A57 LINK ROADS

TR010034

RESPONSES TO DEADLINE 4 SUBMISSION

CPRE Peak District and South Yorkshire Branch

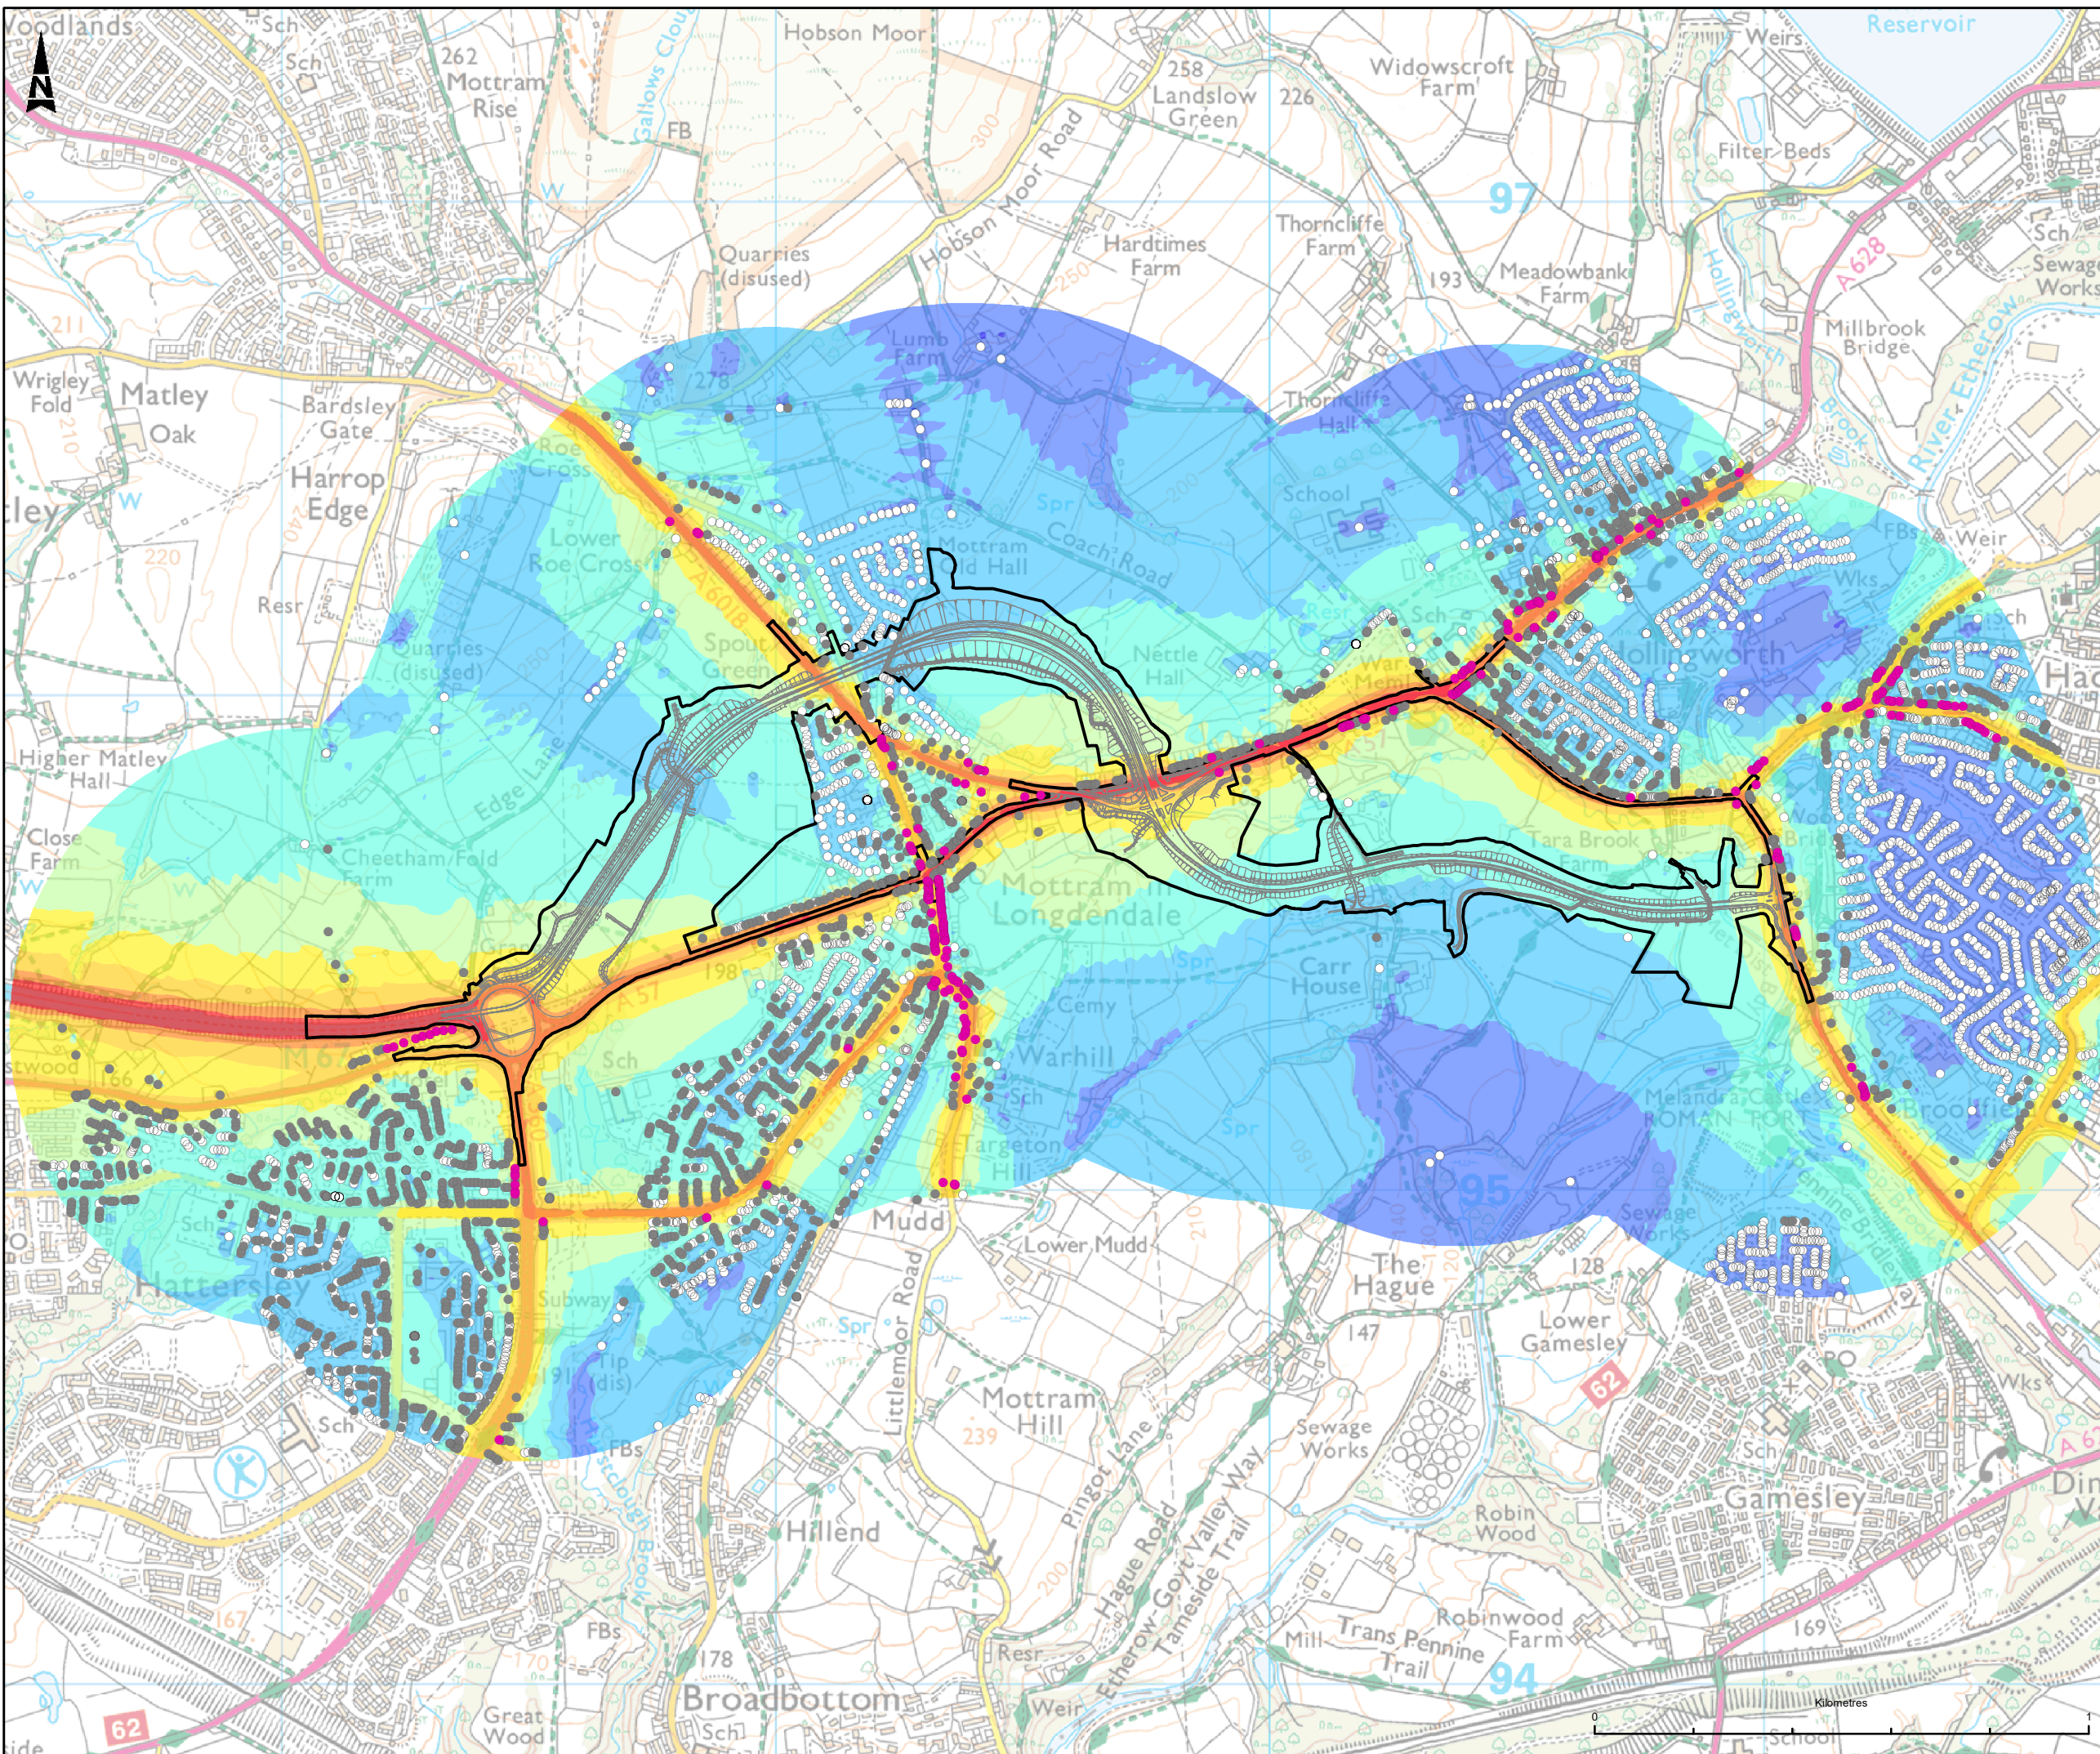
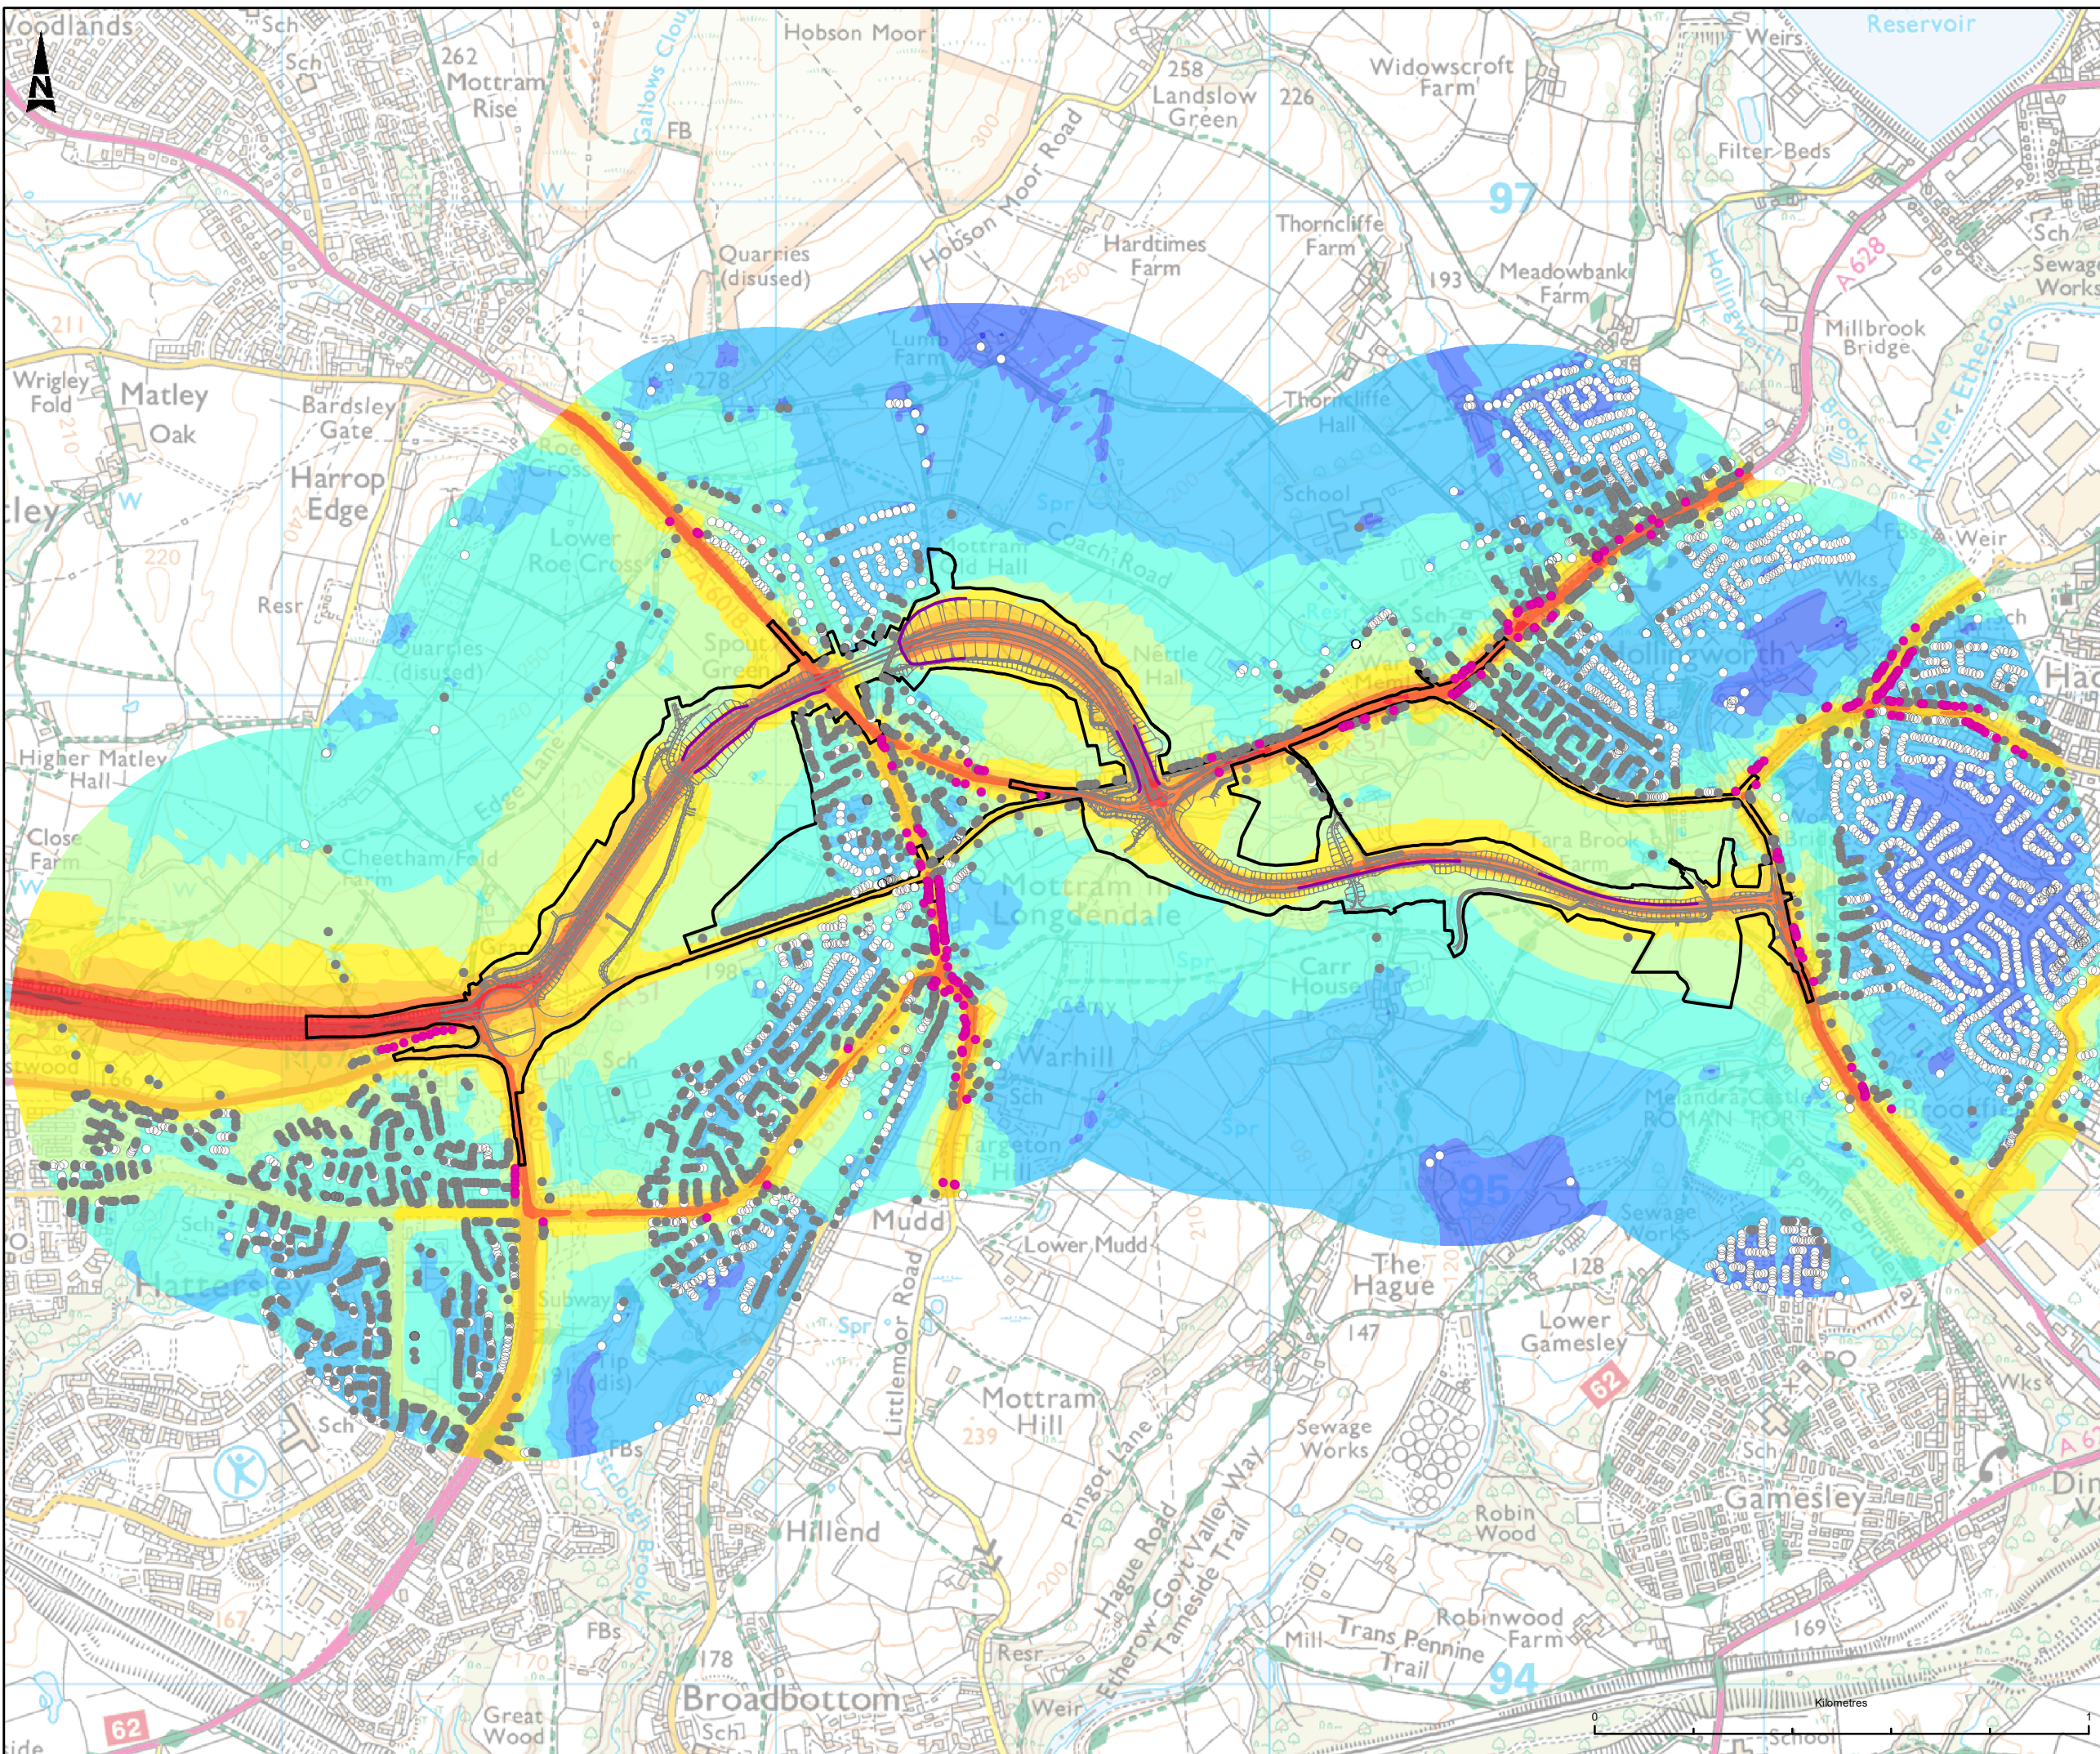
- 1) The assessment in the table and the map of noise contours confirms our statement that the tranquillity in the vicinity of the scheme would be substantially harmed and local amenity impaired for those using the footpaths.
